# CITY OF ALBUQUERQUE

**Re: A Class RV Storage  
Grading and Drainage Plan  
Engineer's Stamp date 5-6-11 (D-16/D002A3)**

ENGINEER'S SEAL	A CLASS RV/STORAGE @ JOURNAL CENTER 7950 JACS LANE GRADING AND DRAINAGE PLAN	DRAWN BY WCWJ
		DATE 10-18-11
DAVID SOULE P.E. #14522	Rio Grande Engineering 1608 CENTRAL AVENUE SE SUITE 201 ALBUQUERQUE, NM 87106 (505) 872-0888	21110-LAYOUT-10-12-11
		SHEET #
		JOB # 21110

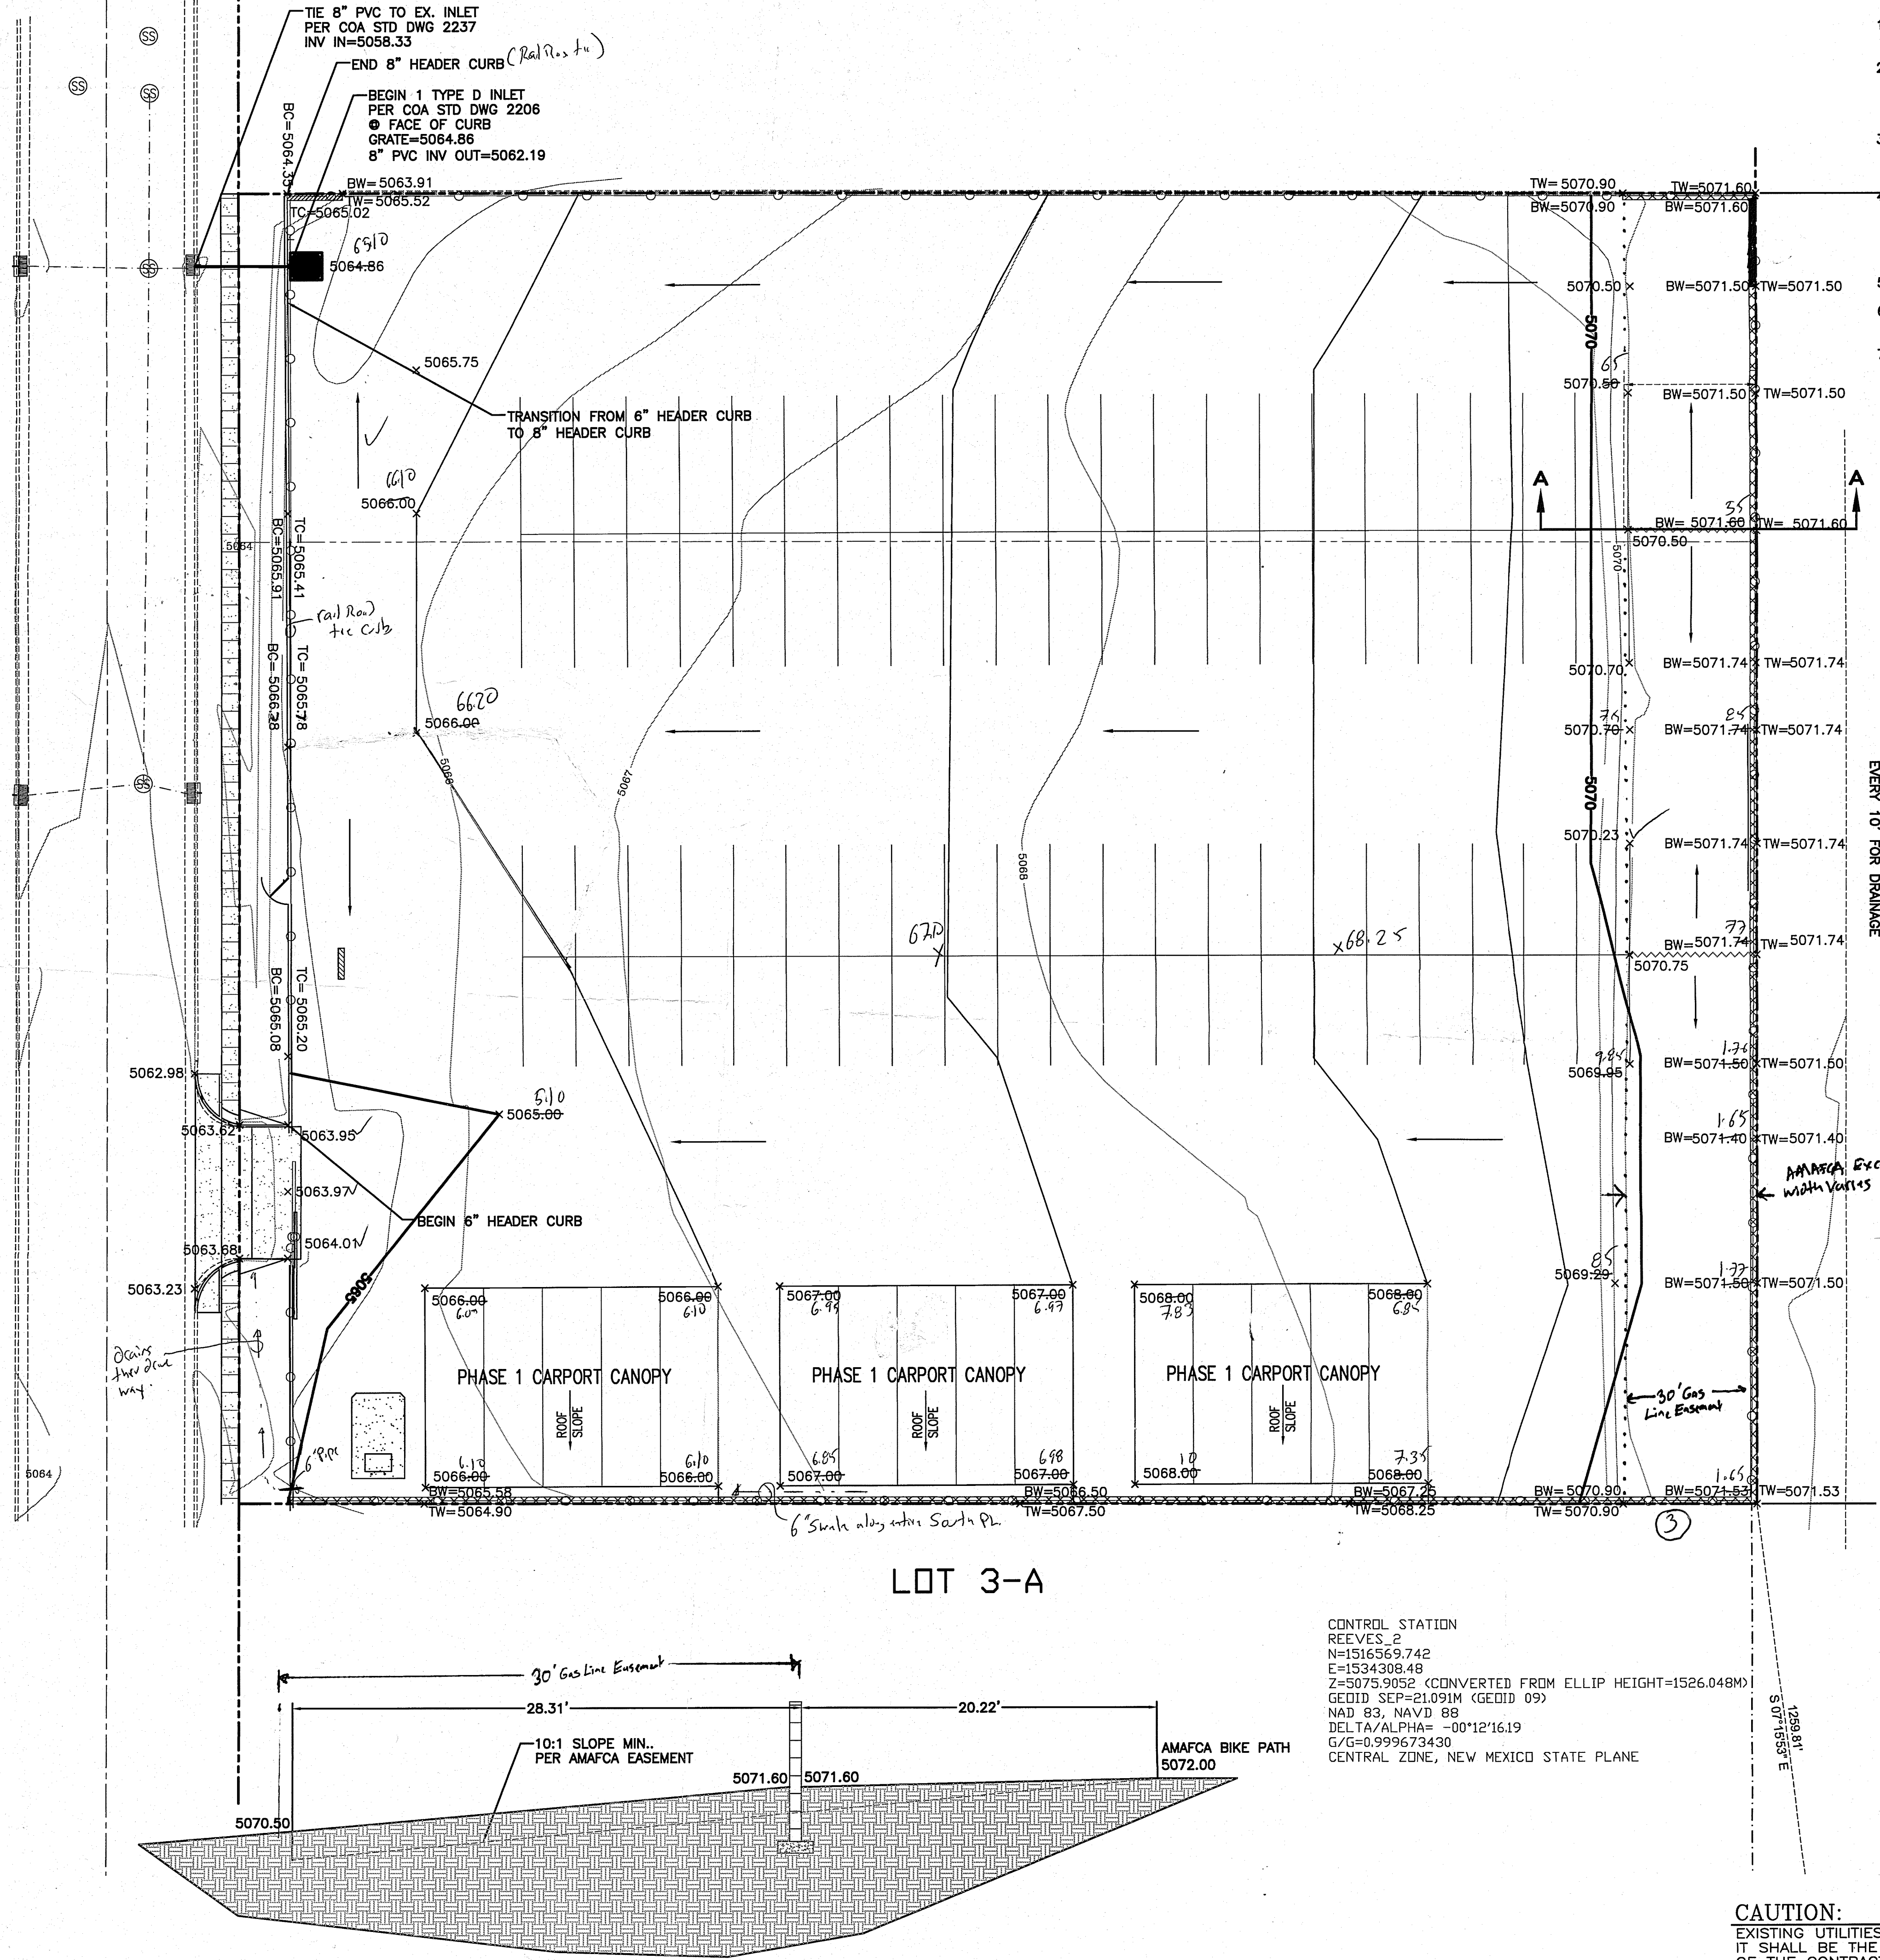
- A basin map is needed.
- Existing Calculations are needed.
- Proposed and existing contours are needed.
- The sidewalk culvert is no longer acceptable unless other means can not be achieved. In this case I believe that tying into the back of the existing inlet would be better, or having the flows exit through the entry way.
- How are the flows being affected to the north and south of this site?
